47 Northaw Road East
Cuffley
Hertfordshire
EN6 4LU

5th March 2017

Re: Application 6/2016/1855/VAR

North Facing Elevation windows

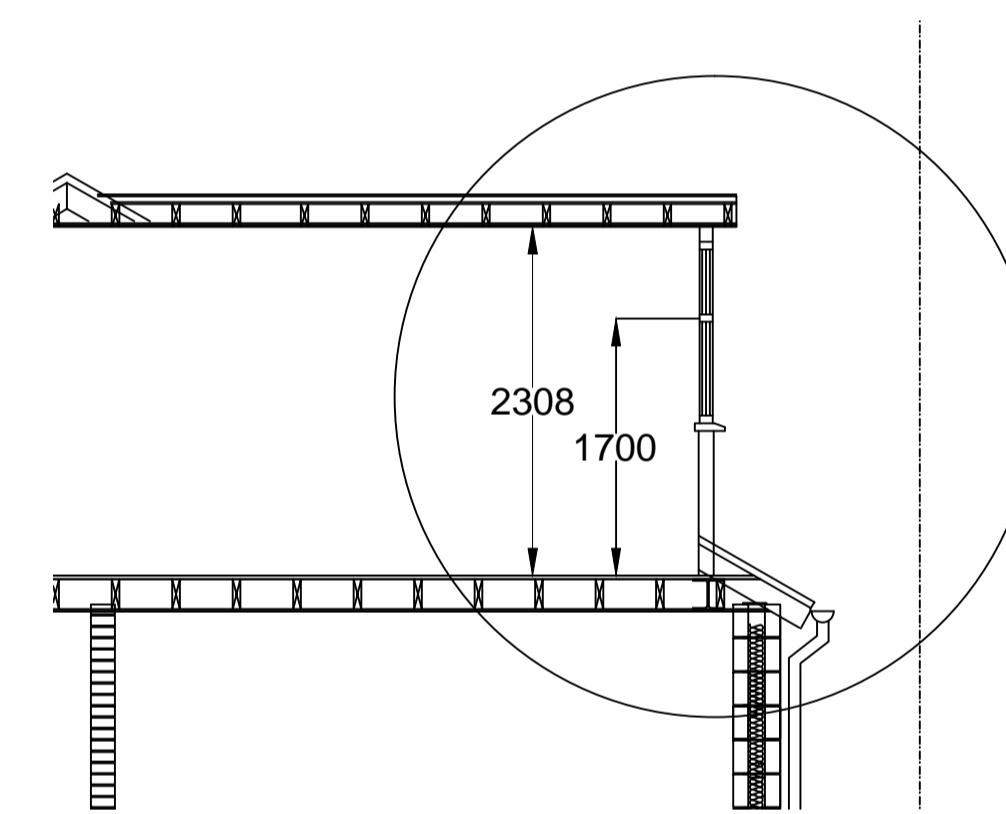
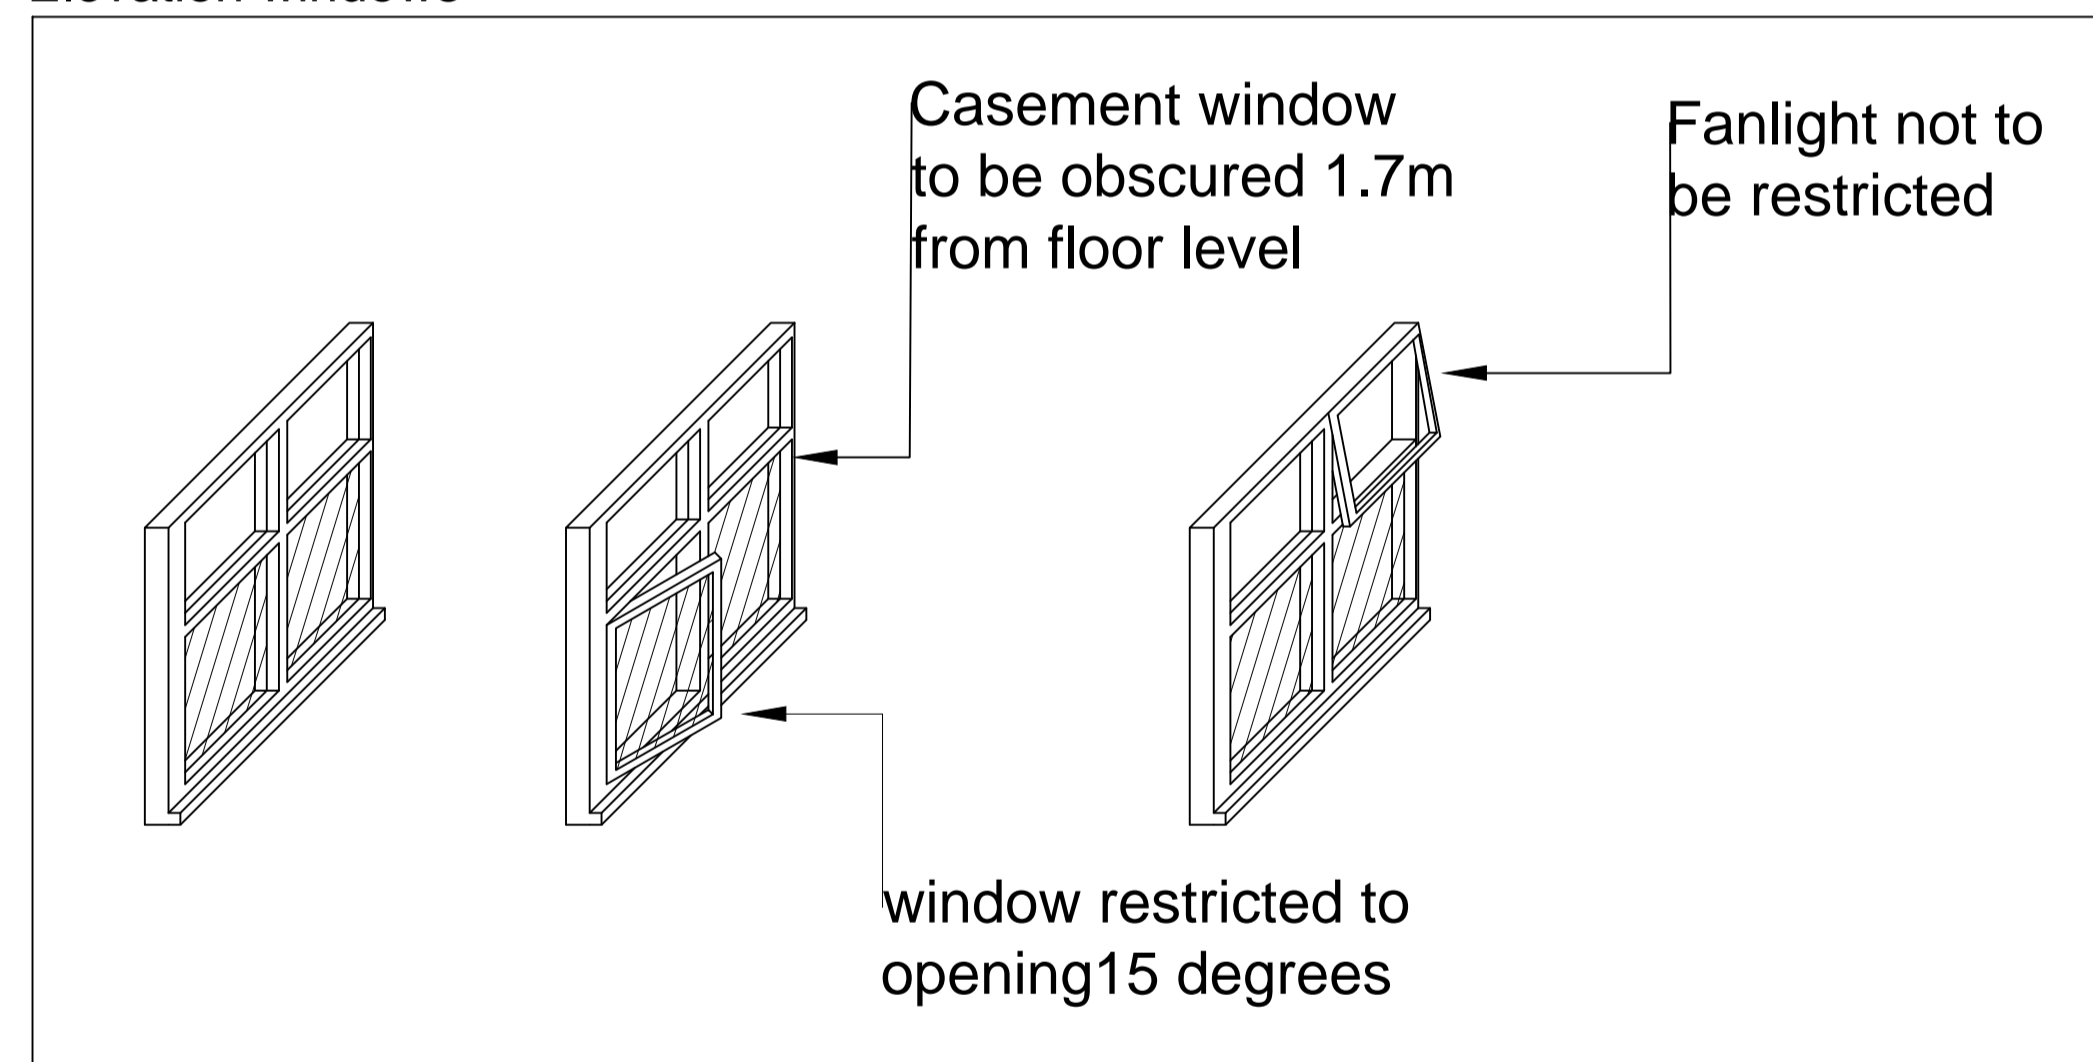
1. Obscure glazing only to 1.7m high and not the 1.8m as per the CDMC decision will mean the appellant will be able to look directly into our bedrooms, staircase and patio through the fanlights.
2. Restrictors on the windows will enable the windows to be opened at any time and although the Planning Department ensure us that this would be a breach and would be enforced if notified the practicalities of this happening are questionable.
